WRITTEN SUBMISSION ON BEHALF OF WEST CAMEL PARISH COUNCIL.

Following the Issue Specific Hearings (26/02 – 01/03), West Camel Parish Council wish to make the following additional comments and reinforce some areas highlighted in earlier written submissions.

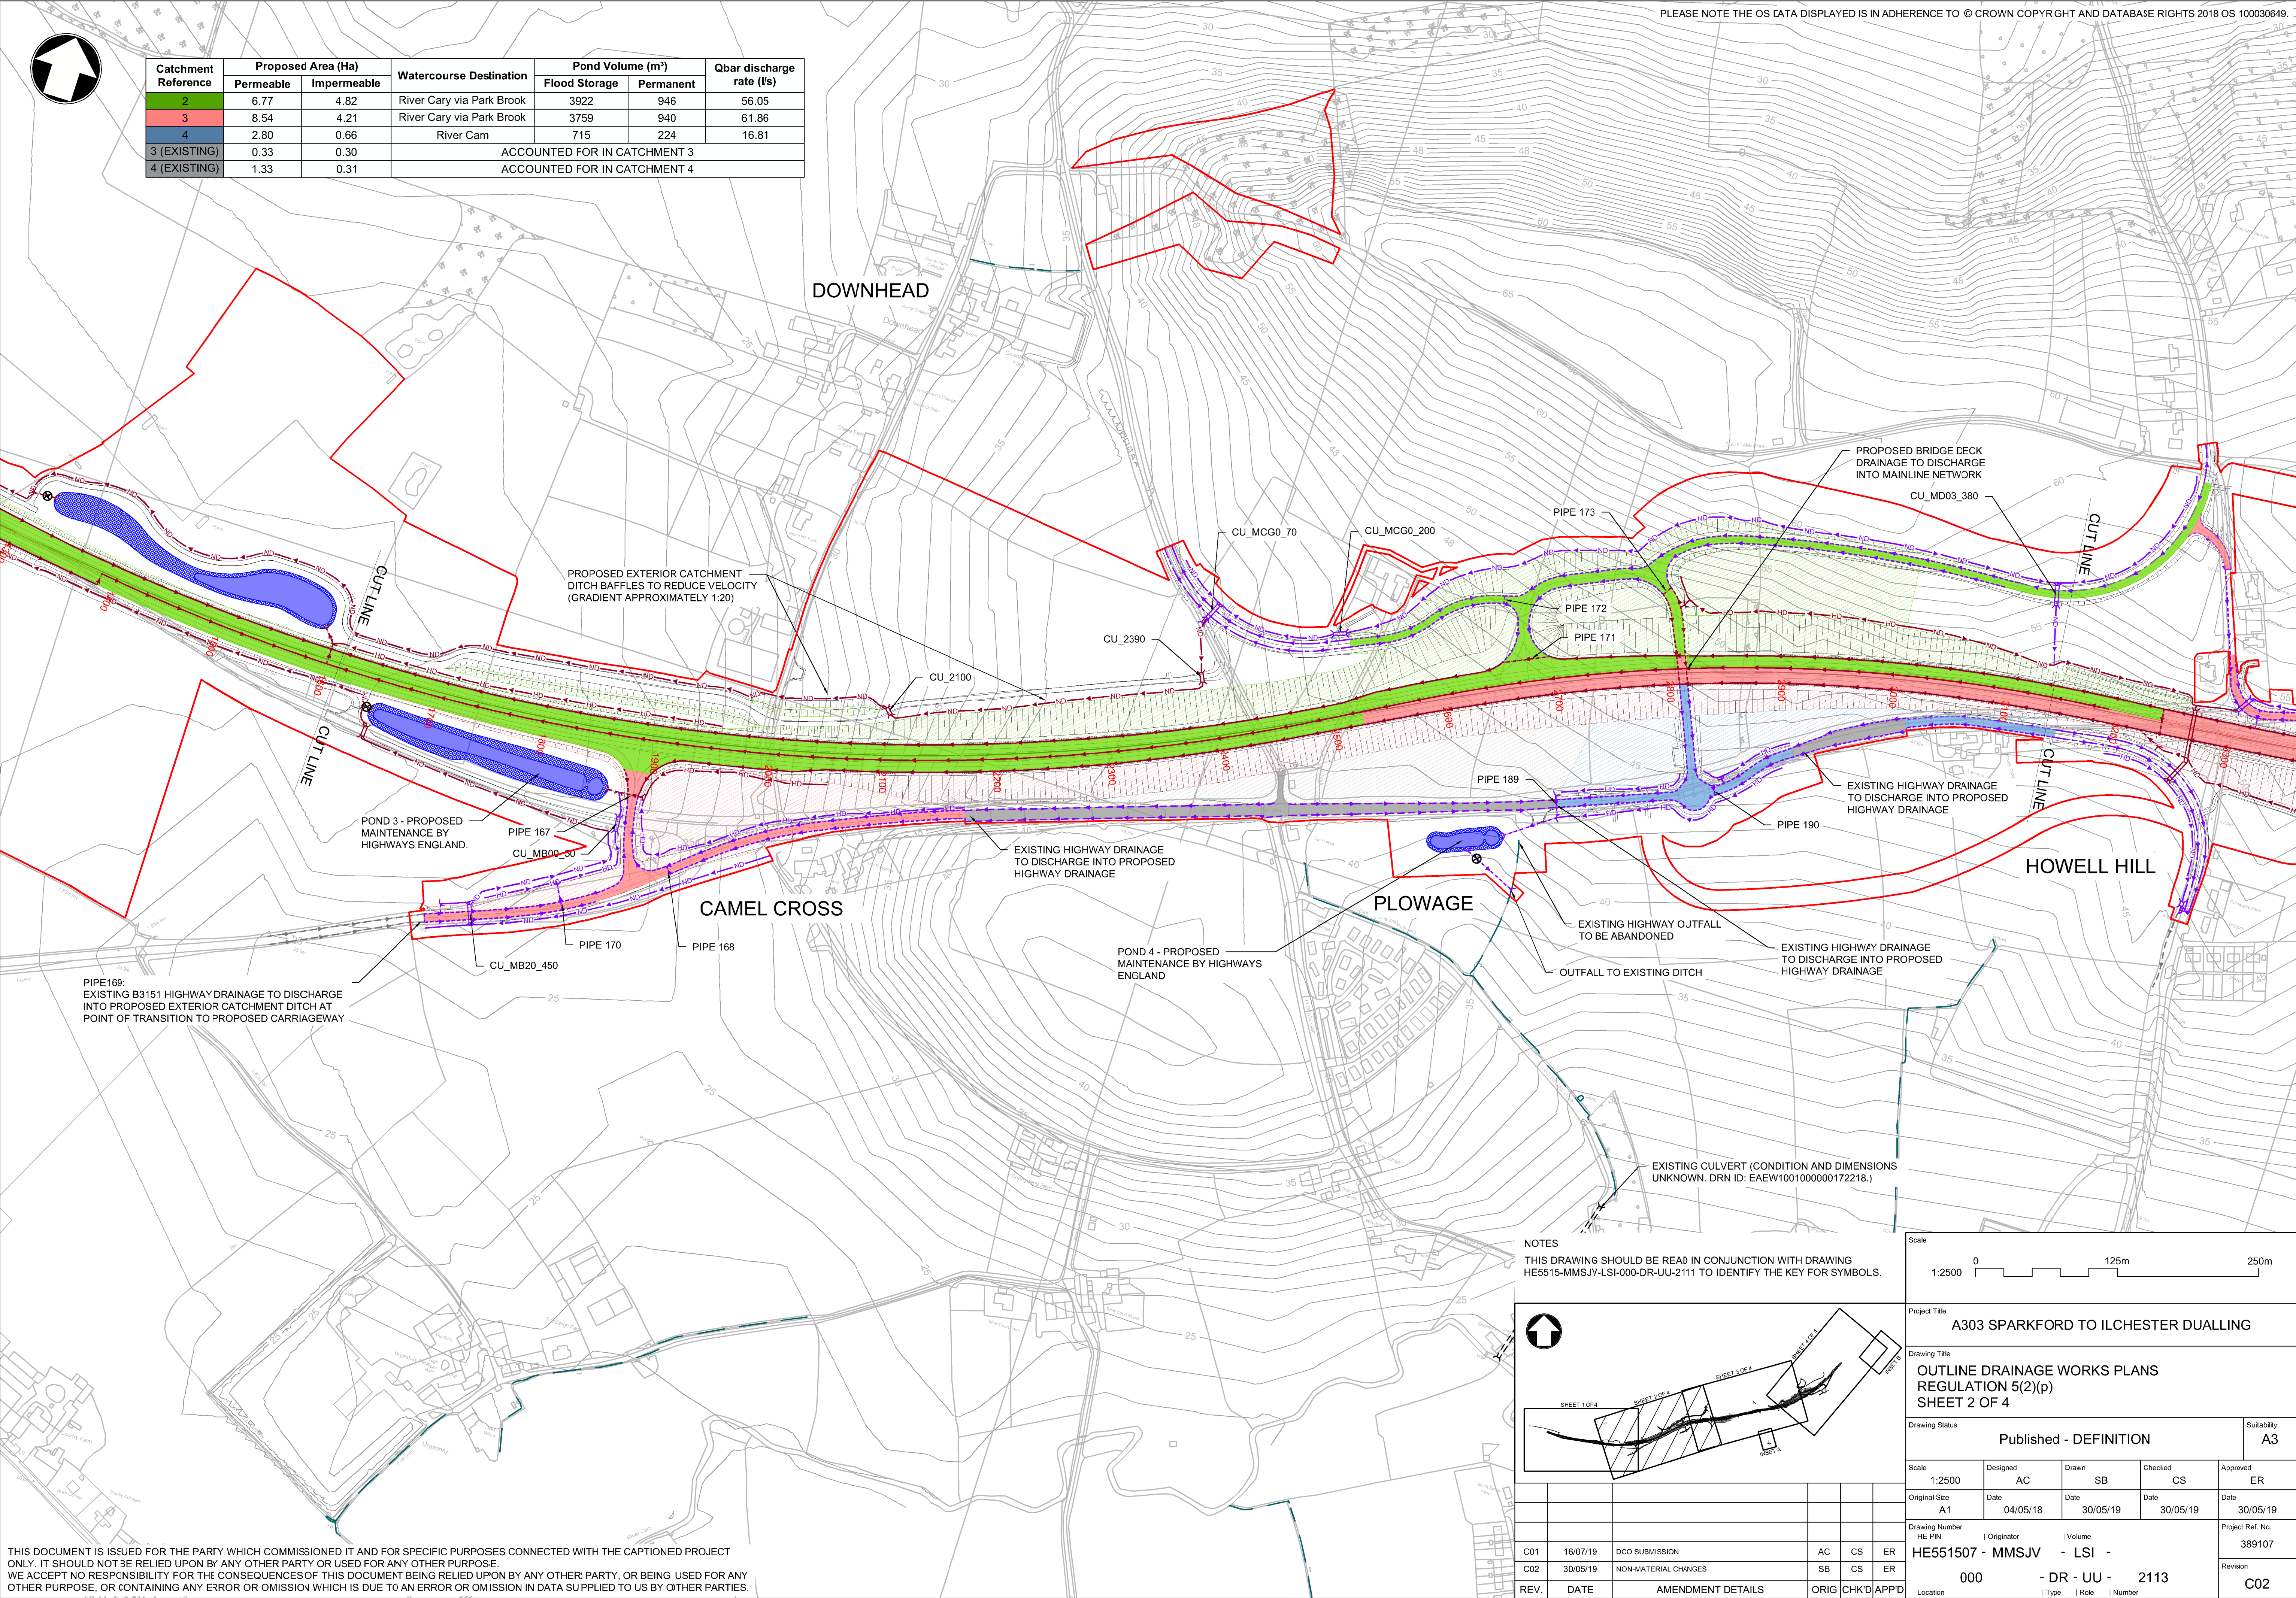
Drainage Works – Steart Hill area. In 2.11 Outline Drainage Works Plans, Drawing 2 of 4, it would appear that elements of the proposed drainage works around Steart Hill and the new connecting carriageway, drain via a proposed culvert under the dual carriageway into existing surface water drains in Howell Hill and thus adding to the discharge rate into the River Cam.

West Camel has a history of flooding and several local schemes have previously been instigated to mitigate the risk of future flooding. H.E. proposals have indicated that all surface water discharge from their proposed scheme will discharge into the River Cary NOT the River Cam. Perhaps the Applicant could clarify this point and reassure Council that either the drawing mentioned has been mis-interpreted or amend their proposals to ensure that no additional surface water is directed towards the River Cam.
